Our Ref: EP/165/19/NMA

**Section 96A of the Town & Country Planning Act 1990 (as amended)
Town and Country Planning (Development Management Procedure) (England) Order 2015 (as amended) - Article 10**

Non-material amendment following the grant of reference EP/166/18/HH for the alteration of rear parapet roof profile and addition of first floor window to southern elevation
100 Sea Road East Preston BN16 1NP

PROPOSED PLANS, ELEVATIONS, ROOF PLAN AND BLOCK PLAN
Minor Amendment for the addition of new window to first floor as highlighted and parapet roof profile

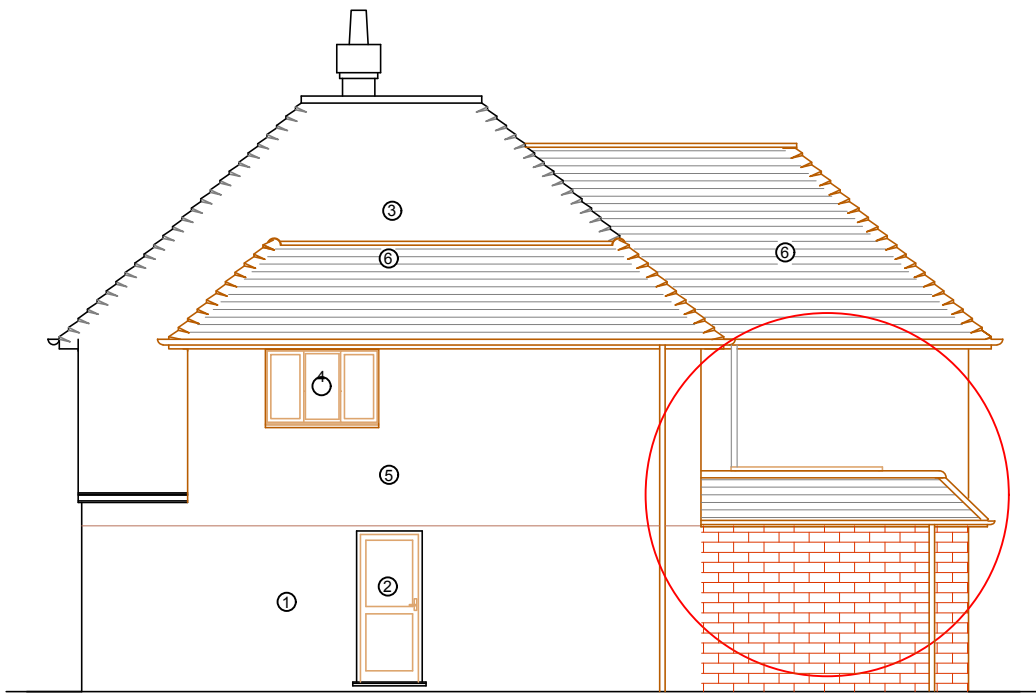
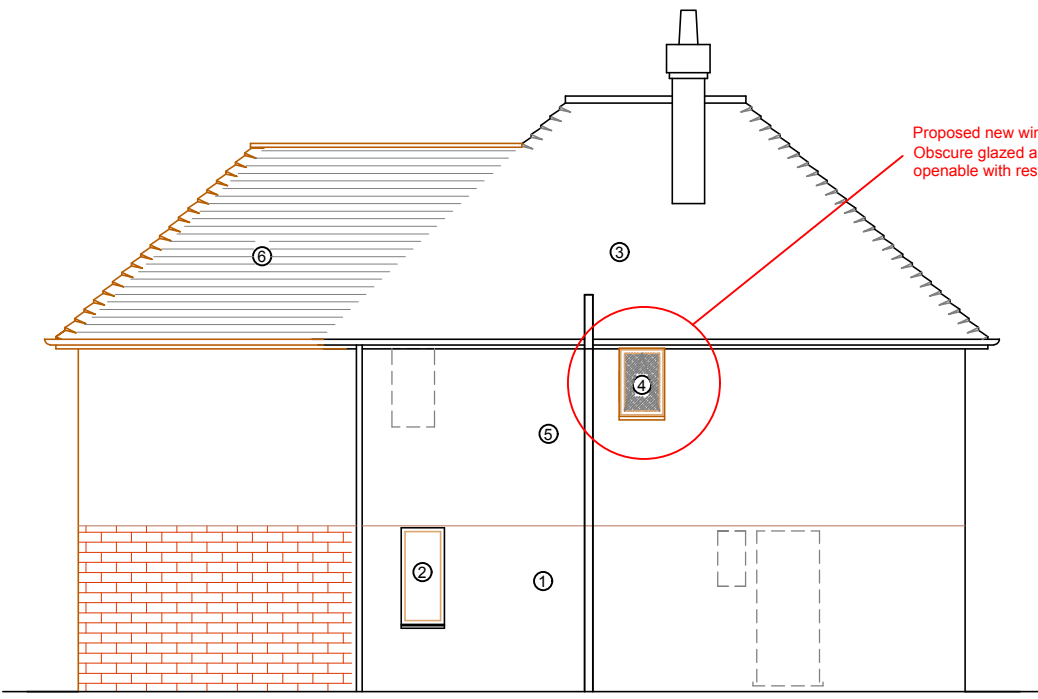
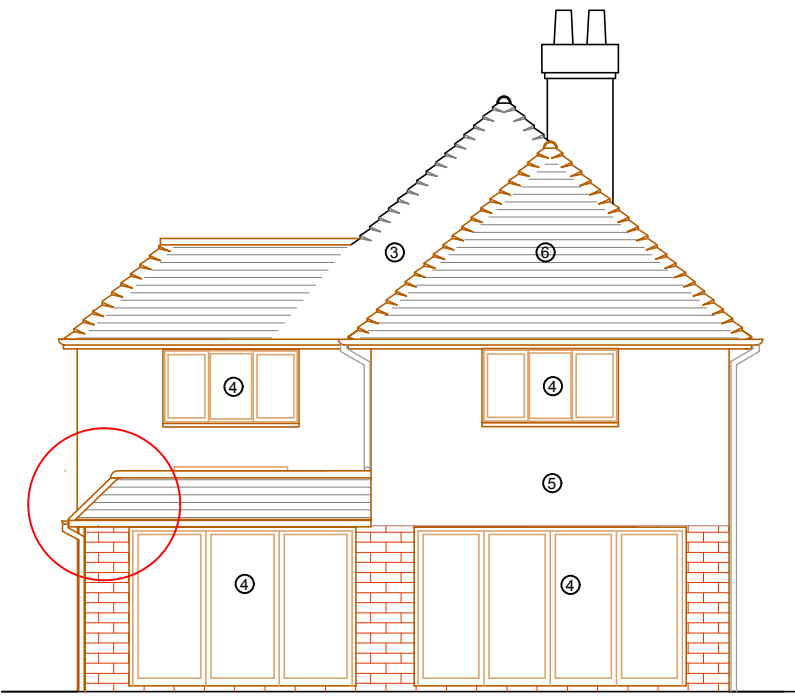
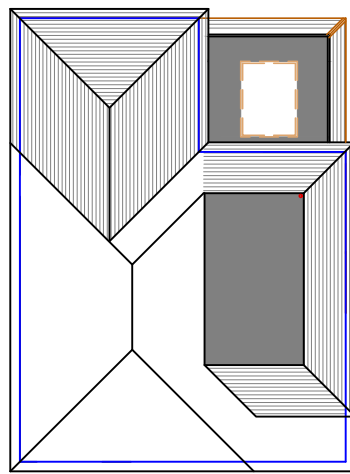
I refer to your recent application for a Non Material Minor Amendment. I note that you seek to alter the rear parapet roof profile, and insert a window into the Southern elevation of the dwelling, at first floor level.

Please note that plan reference 'Proposed Floor Plans, Elevations, Roof Plan and Block Plan - 18075/02R2 - 15/11/2018' has been replaced by 'Proposed Plans, Elevations, Roof Plan and Block Plan - Minor amendment of the addition of new window to first floor as highlighted and parapet roof profile - 183011/04 - 05/07/2019', a letter dated 25th January 2020 relating to the proposed windows and 'Defender Ferritic - Defender Austentic - 615 - 40 - 1300 - 850 - 6'.
